CPP Project 11355

Project: Inner City High School

Please find herein a summary of expected wind conditions around the proposed Inner City High School Development. This letter specifically addresses a request from the Department of Planning regarding the likelihood of wind mitigation measures and the requirement (or lack thereof) for further studies. A more detailed qualitative assessment of the pedestrian wind environment may be found in Cermak Peterka Petersen (2017).

1 PLAN Level 4 Games Terrace
1:200

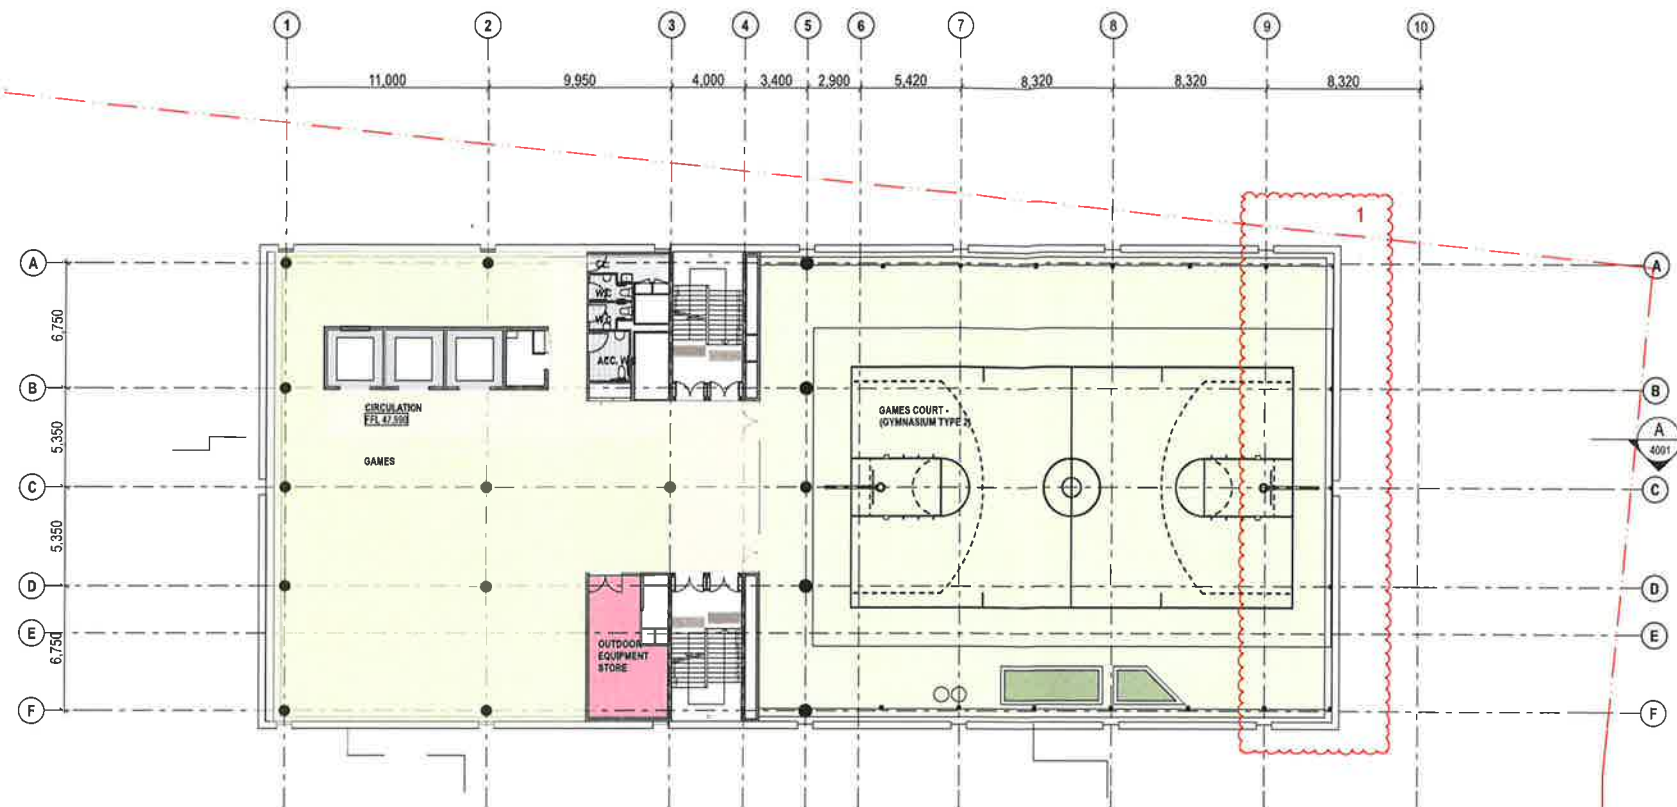
On Levels 2 and 3, the solid balcony screens on the east and west sides will allow reasonably amenable conditions. A high (>1.5m) balustrade would be beneficial in creating calm conditions for a greater proportion of the time. The level 4 games terrace will be affected by downwash flows from the tower levels above, and higher velocities would be anticipated, particularly near the building corners and tower façade. For the colonnade area close to the building in particular, screening on the east and west sides would be suggested to improve conditions.

1 PLAN Level 8 Tower Terrace
1:200

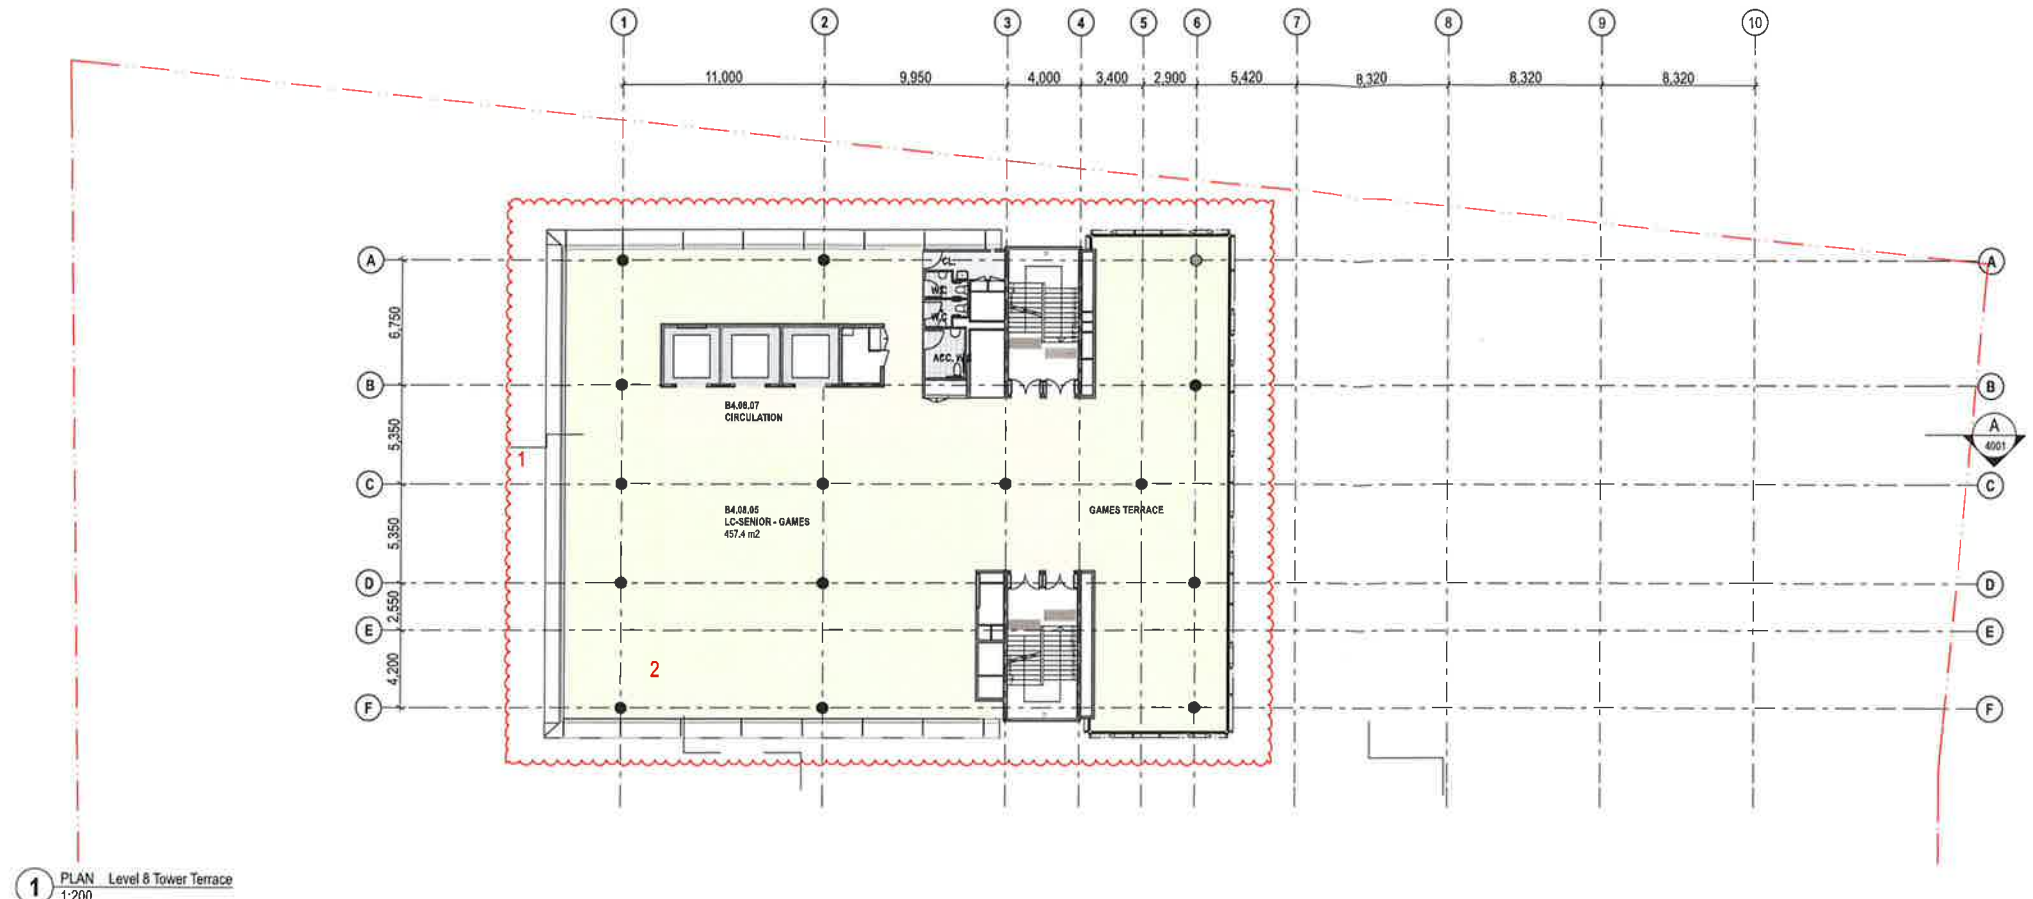
The open levels on Levels 1, 4 and 8 may experience strong cross flows for a significant proportion of the time, as wind is compressed and accelerated through the slot in the façade and across the level. These areas are expected to be acceptable for transient outdoor-type activities only. It is noted the design includes porous mesh around these areas, with a solidity of approximately 25%. This may marginally improve the wind conditions, though if these levels are to be used for long-term stationary activity more often, it would be recommended to increase the solidity of the screens to approximately 60-70%. Alternatively, vertical obstructions distributed across the level could be used to create localised calm spaces.
